Re: Booksales & Office
120 Jefferson St NE
Engineer's/Architect's Stamp 11-15-19 (K17D119)

Based upon the information provided in your submittal received 11-20-19, the above referenced plan cannot be approved for Building Permit until the following comments are addressed:

**1) TCL PLAN**  
Scale: 1" = 20'-0"

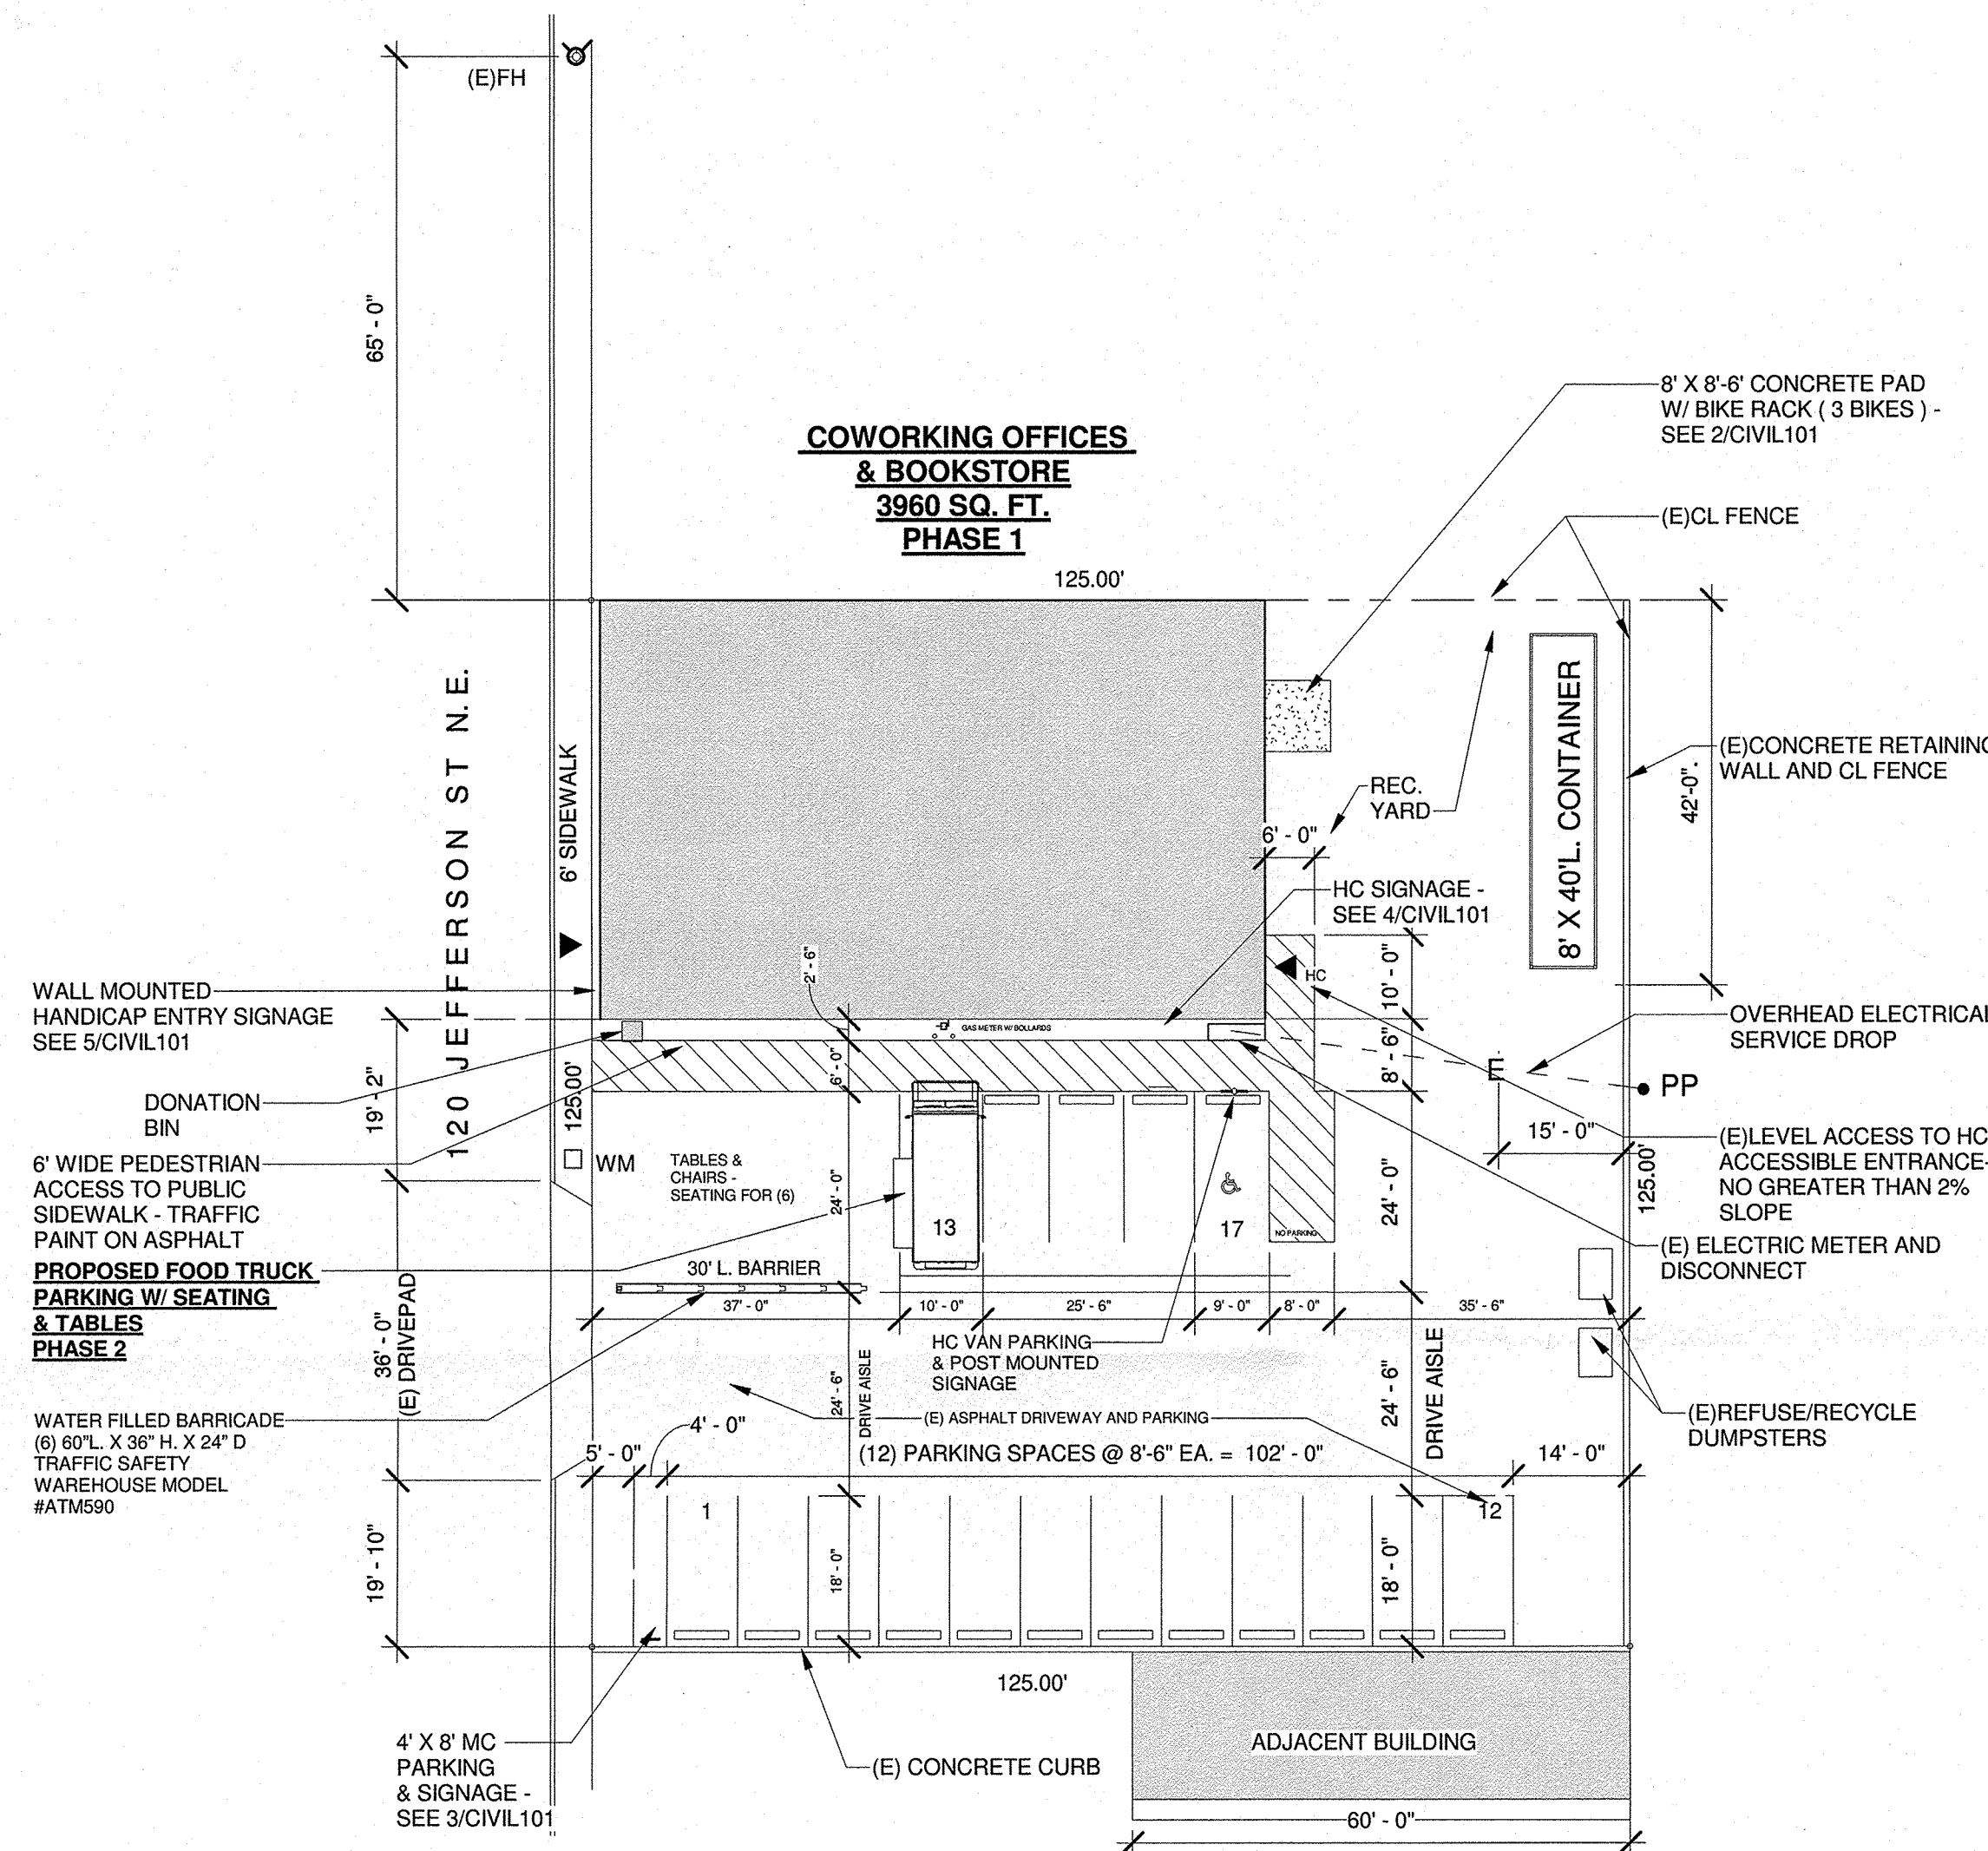
1. Please show a vicinity map showing the location of the development in relation
2. The dimensions on google earth contradicts what has been shown on the drawings:
